RE: 300 Allen Avenue, Portland, Maine
Letter of Correspondence #5

Gorrill-Palmer Consulting Engineers, Inc. is pleased to respond to the review comments we received from your letter dated September 23rd and the previous review comments from Jim Seymour of Sebago Technics dated September 5th regarding the above referenced project. For ease of review, each of your comments have been repeated below followed by our response.

Comments by Kandice Talbot/City of Portland Dated 09/23/03

Comments by Jim Seymour/Sebago Technics, Inc. Dated 09/05/03

INLET TRASH RACK
NOT TO SCALE

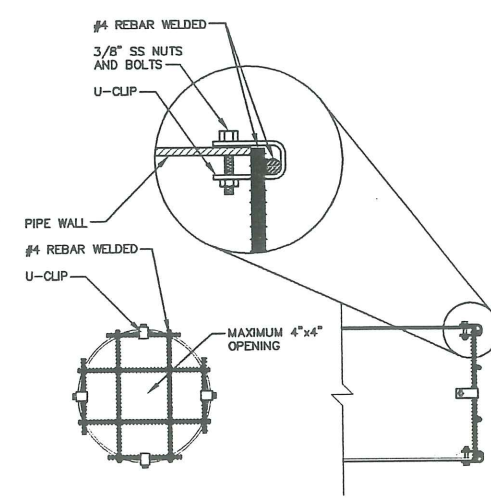
Comment 4 – If the City allows for the additional stormwater flows to enter their combined sewer system, then the culvert facing Short Street shall be designed with a trash rack to prevent large obstructions from entering the sewer and possibly causing plugging in other downstream structures. An optional design could be a field inlet. It could be used in a manner that a flow control device could regulate flows entering and prevent sewer gases from being possibly exhausted, as the case may be with an open culvert tied to an active sanitary sewer.

Response – As part of this submission the culvert facing Short Street, is proposed to be removed and replaced with a new culvert. The invert into this culvert has been raised, such that flow from the sewer cannot exit through the culvert. The field inlet is proposed with a trash rack.
